Application for Planning Permission

Development: Retention of 3 No. flats as previously approved under BR/162/20/PD. This application is in CIL Zone 4 (Zero Rated) as flats.
Location: 34 Sudley Road Bognor Regis PO21 1ER

Floor Plan

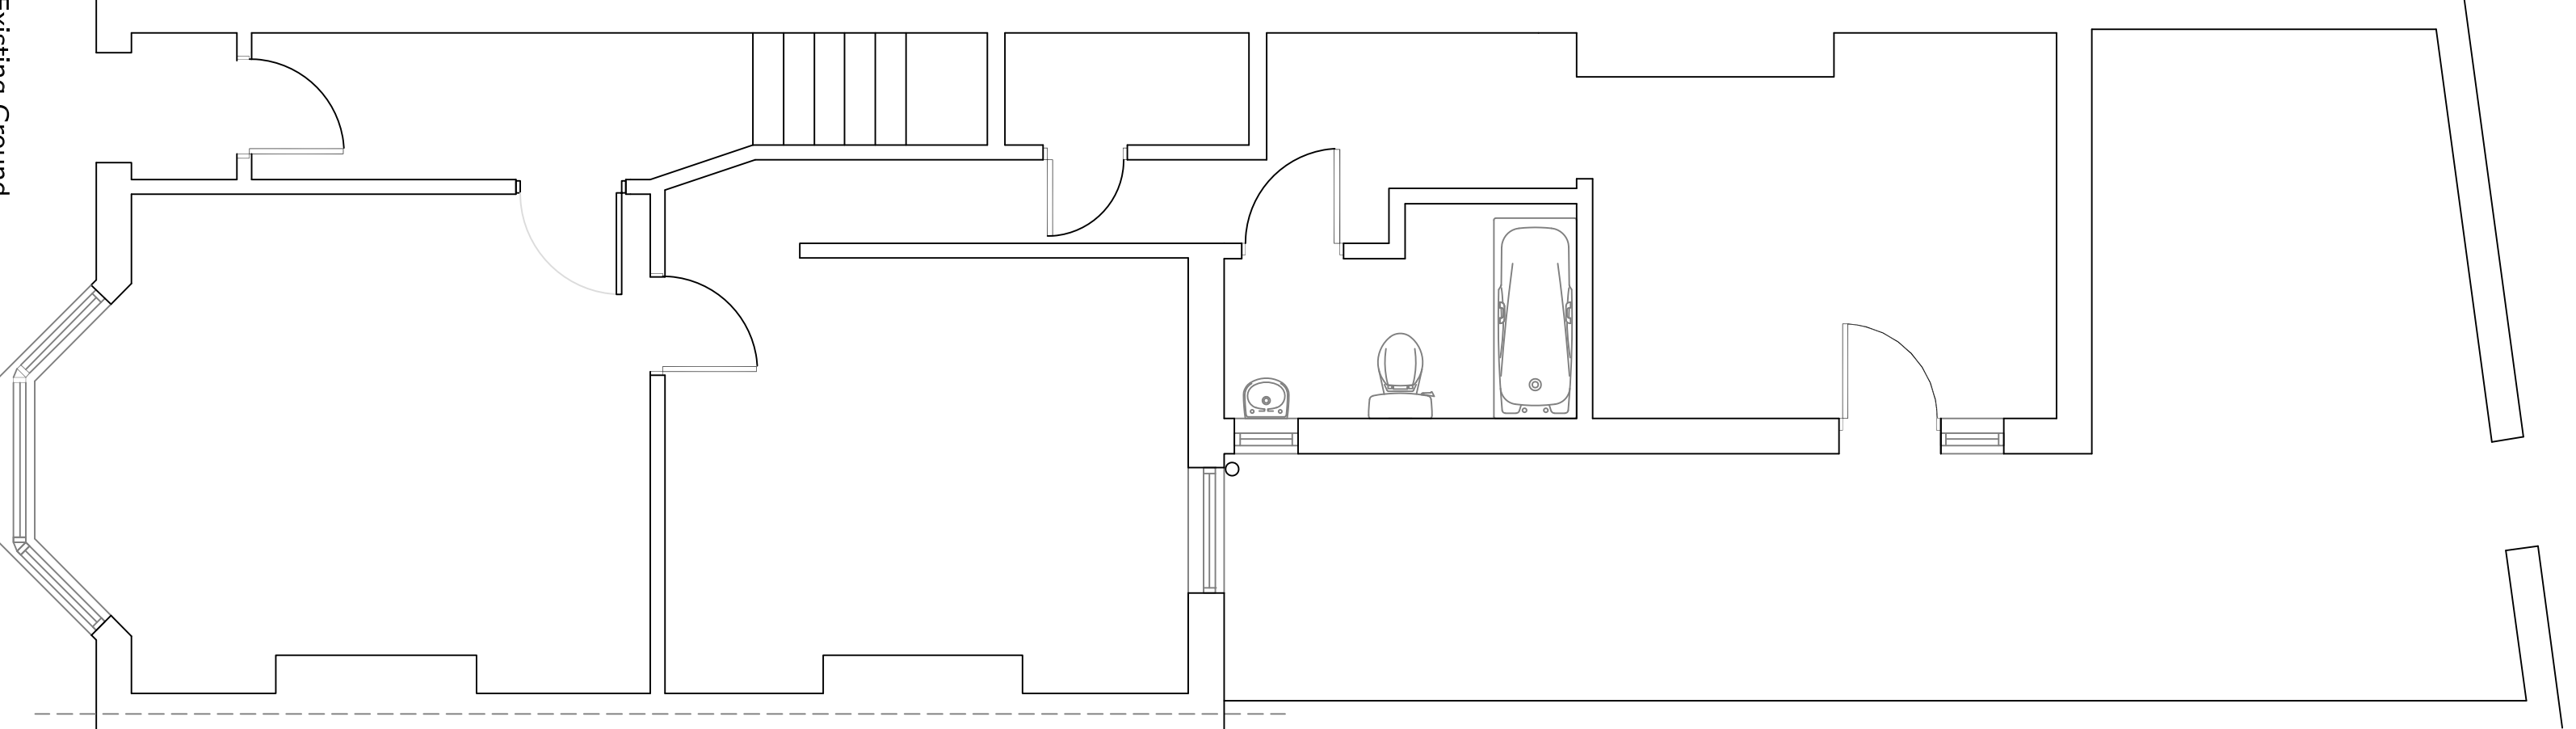
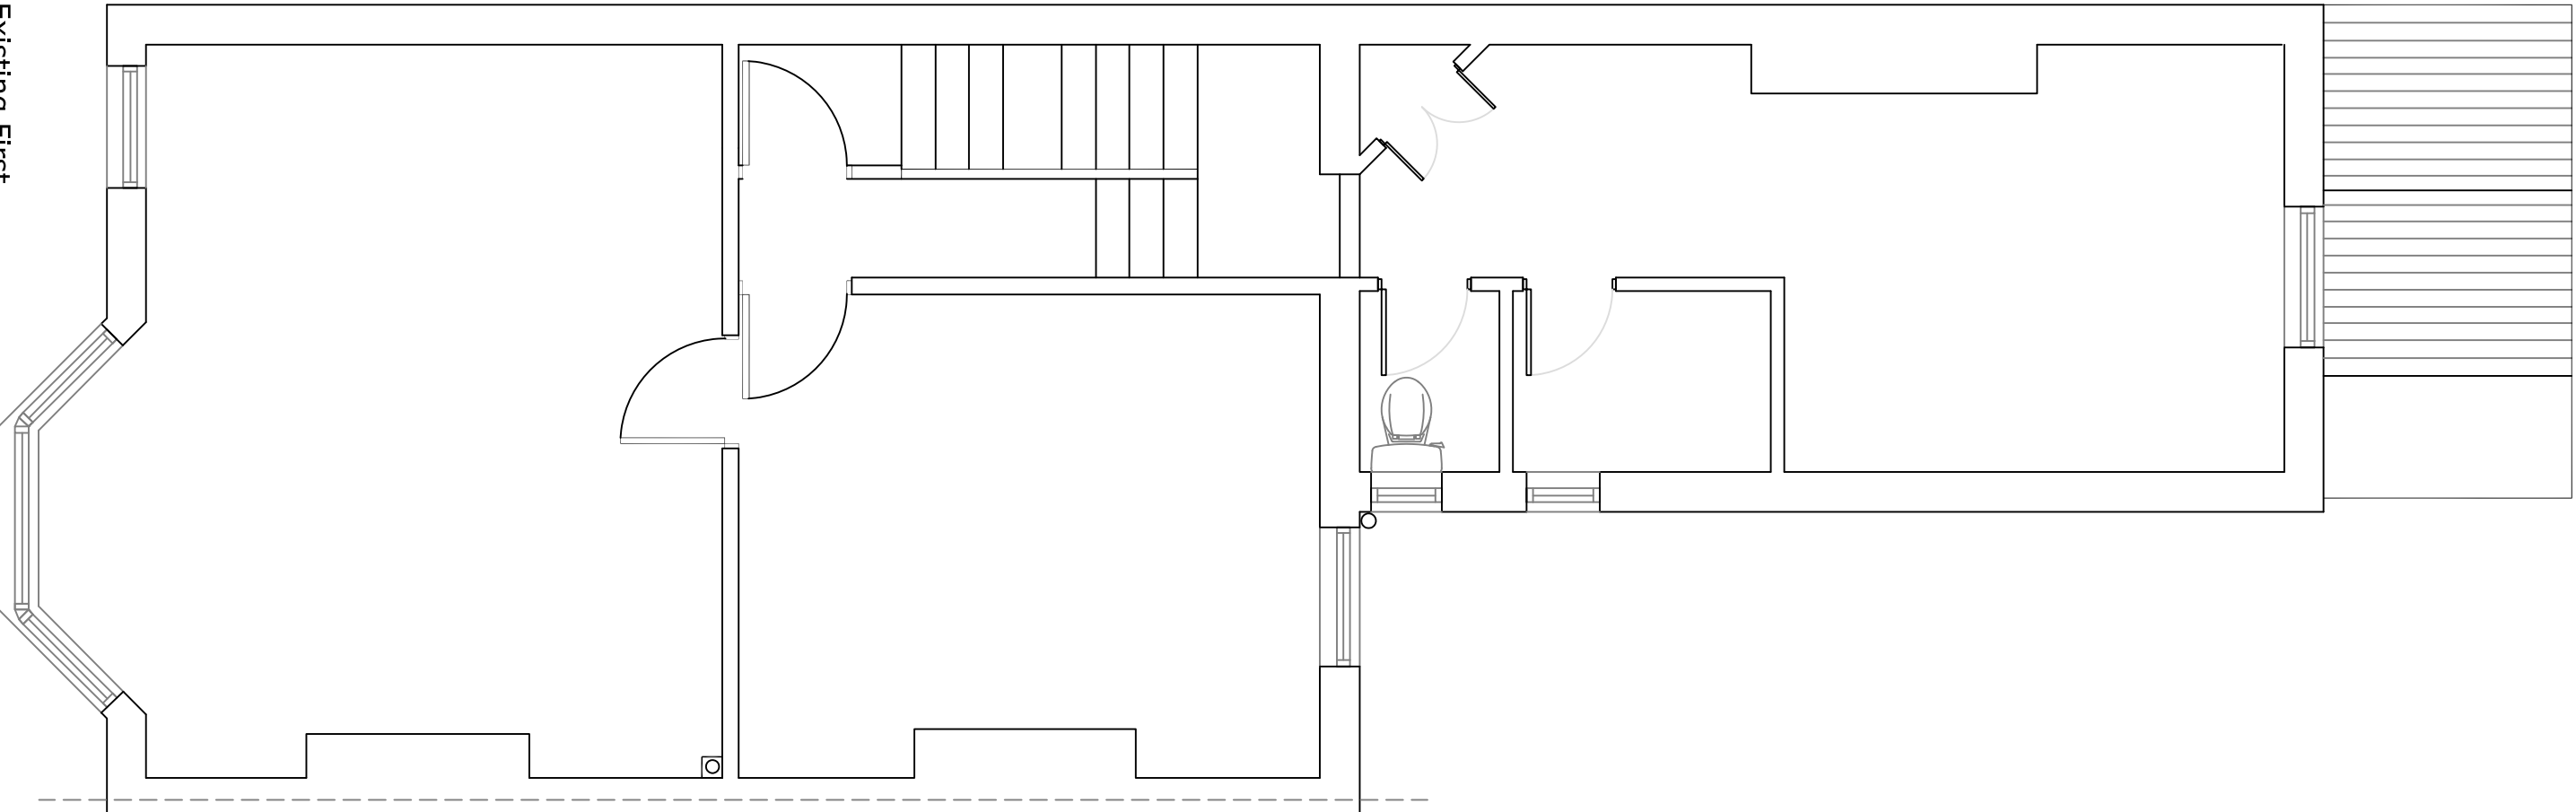
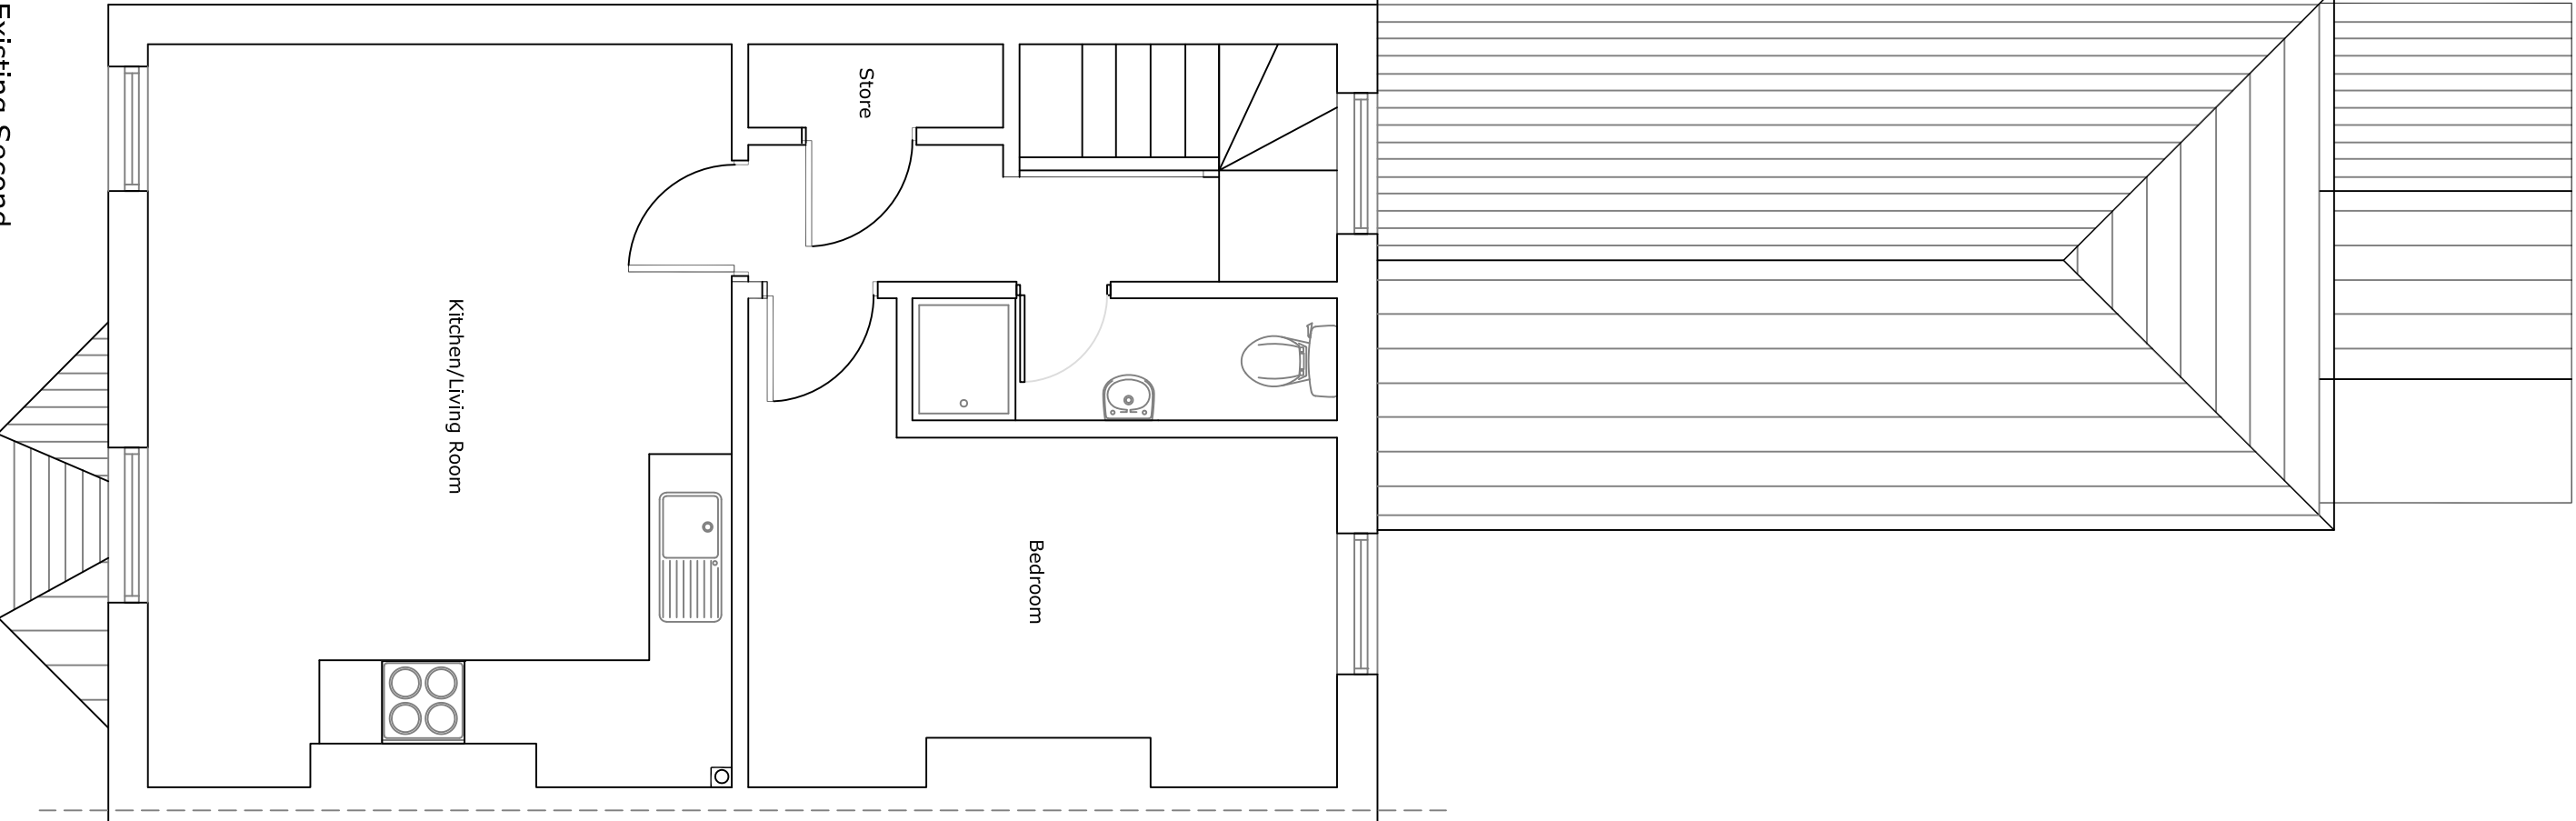
On proposed ground floor plan there is a window on the east elevation (bathroom) but it is not on the proposed east elevation plan, please amend.
